DRAWING TITLE: **LOTS 79-178 & 265-268 & 299**
FENCE KEY PLAN

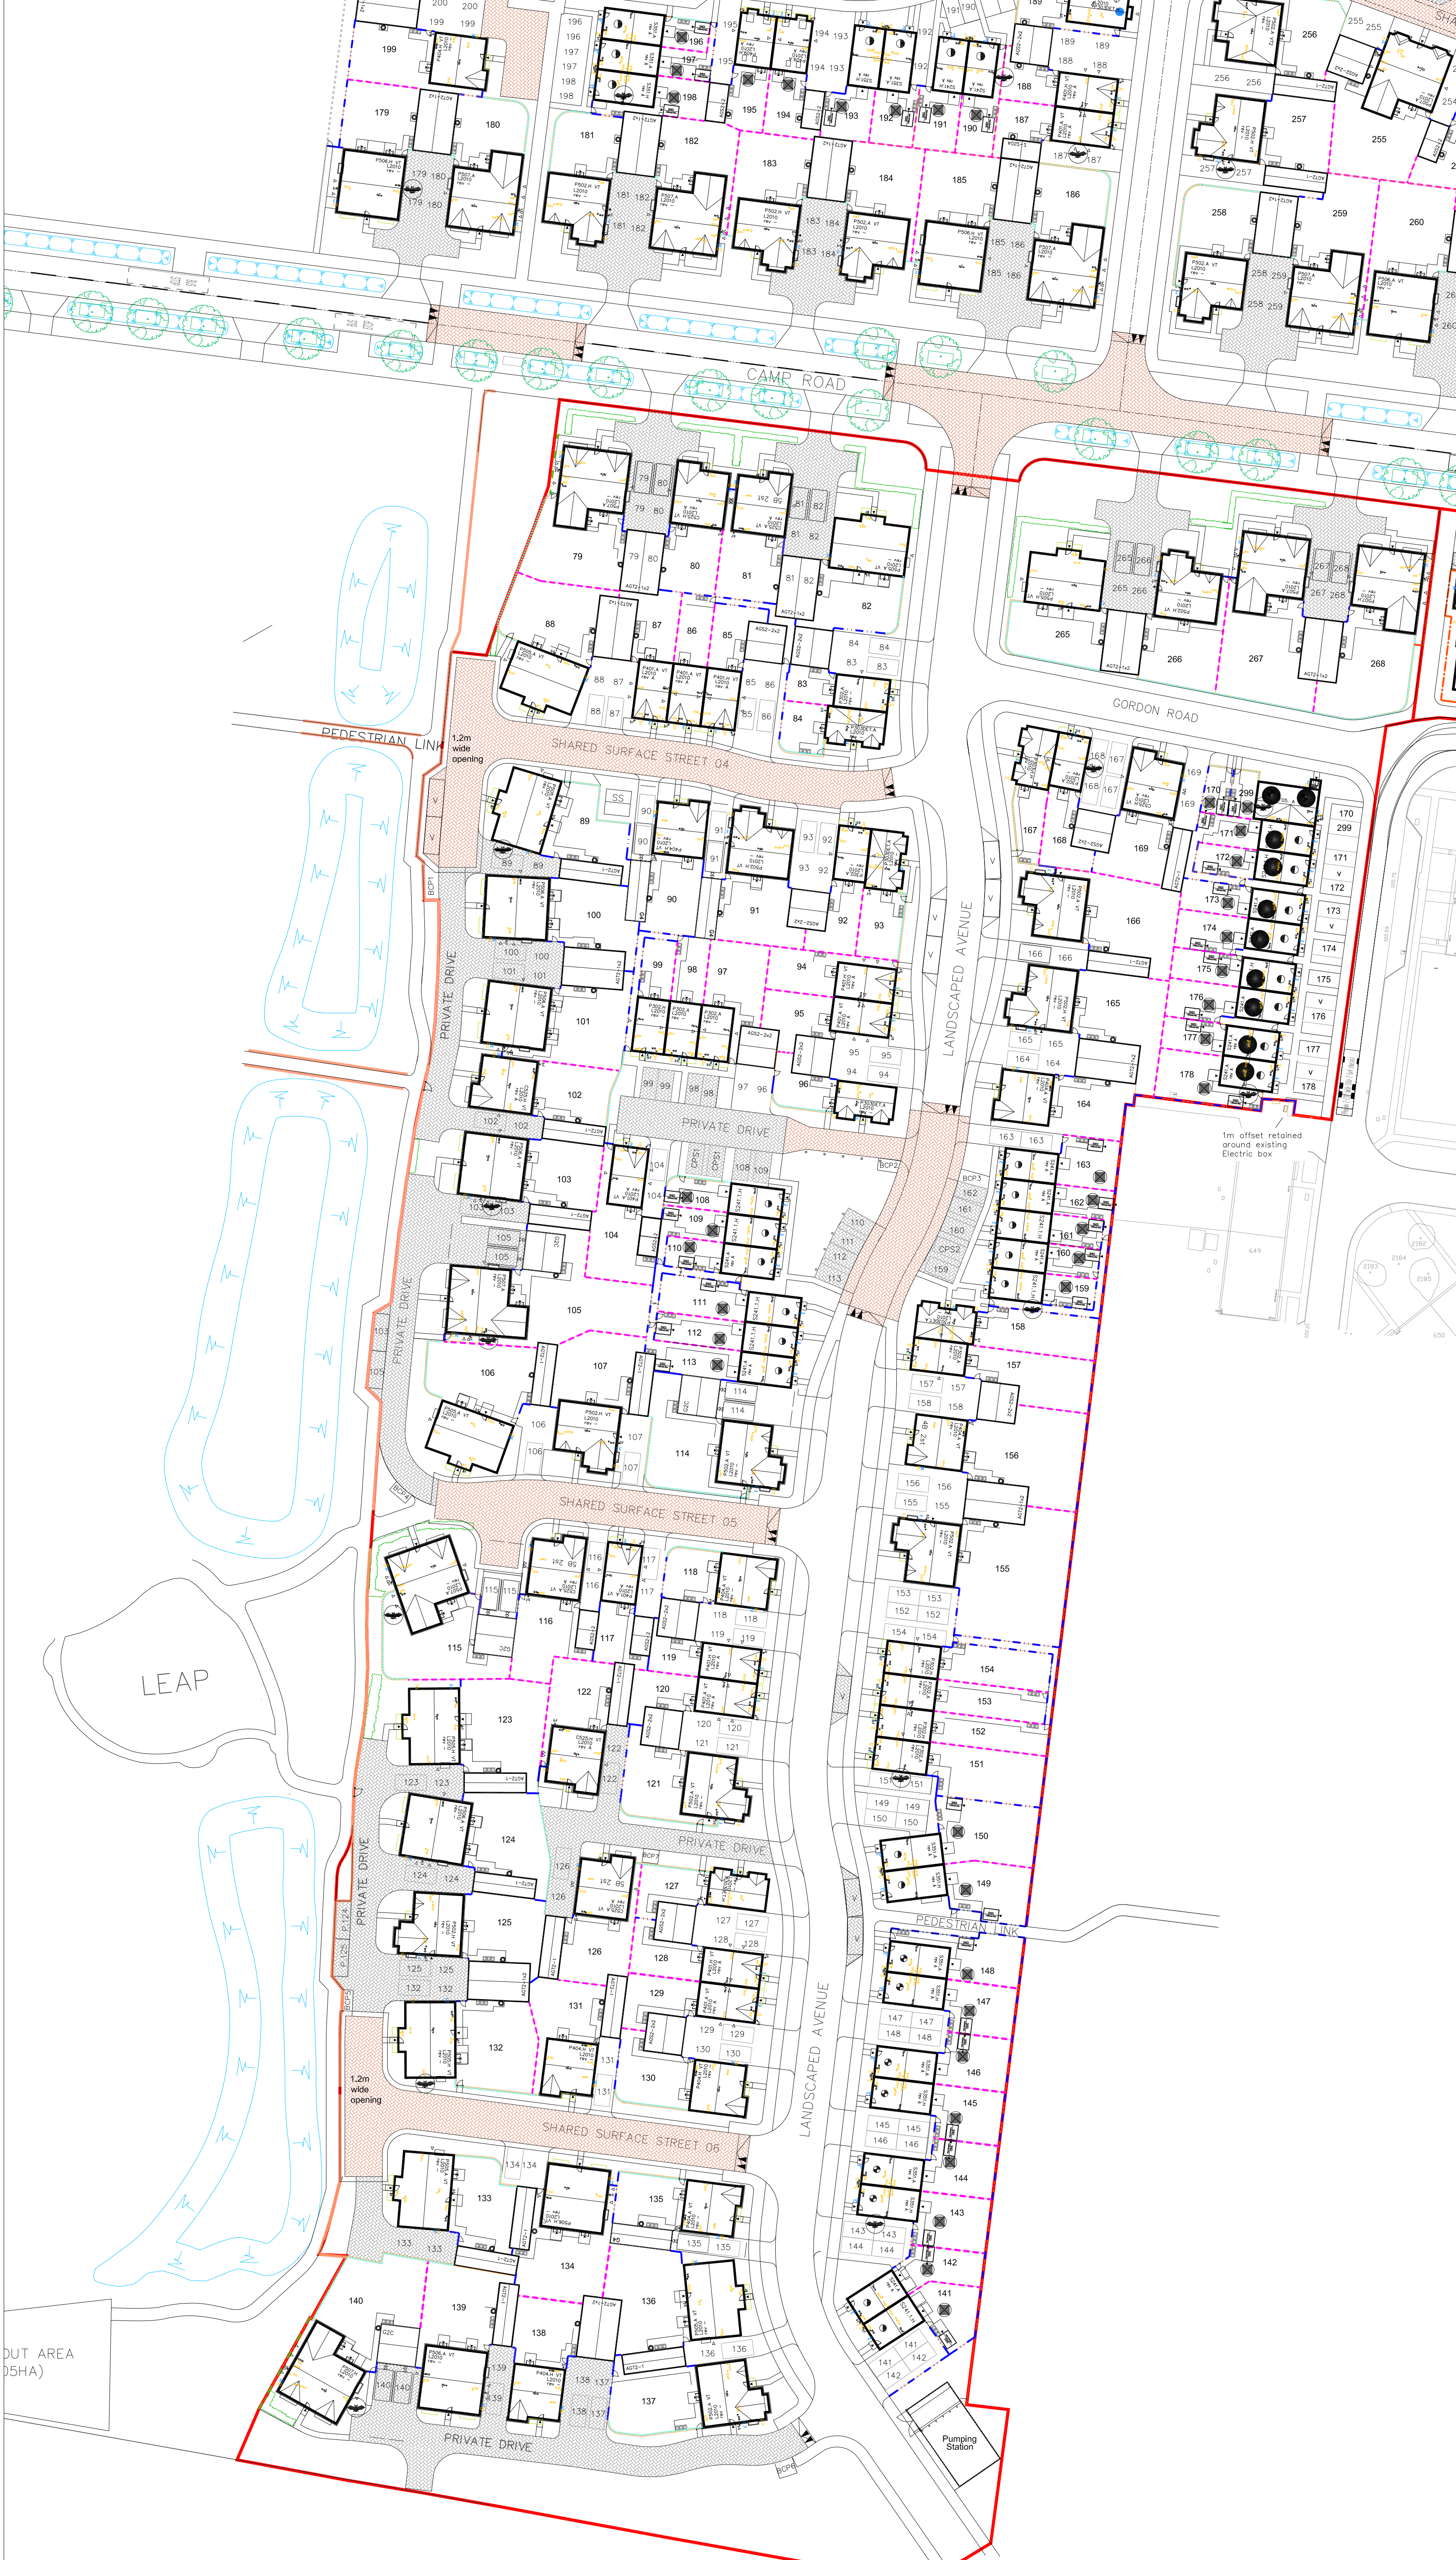
The fence varies in height and is often considerably more than the stated 900mm.

Although the LPA forced Bovis Homes to put gaps in the fence in the plans to make them permeable, the nature of the fence makes these gaps very hard to see. Furthermore many of these gaps are non-existent on the actual fence, despite this being a retrospective planning application.

The appellant states "the very nature of these railings is that they are see-through and therefore permeable" however despite being see through from certain angles (not looking from one end to the other) they are certainly not permeable in the sense that the area remains connected for pedestrians (except for small children, which as previously stated is as best a hindrance to parents/carers, at worst dangerous, especially as they are between paths and adoptable roads). This severely impacts accessibility for areas that should be open green spaces.
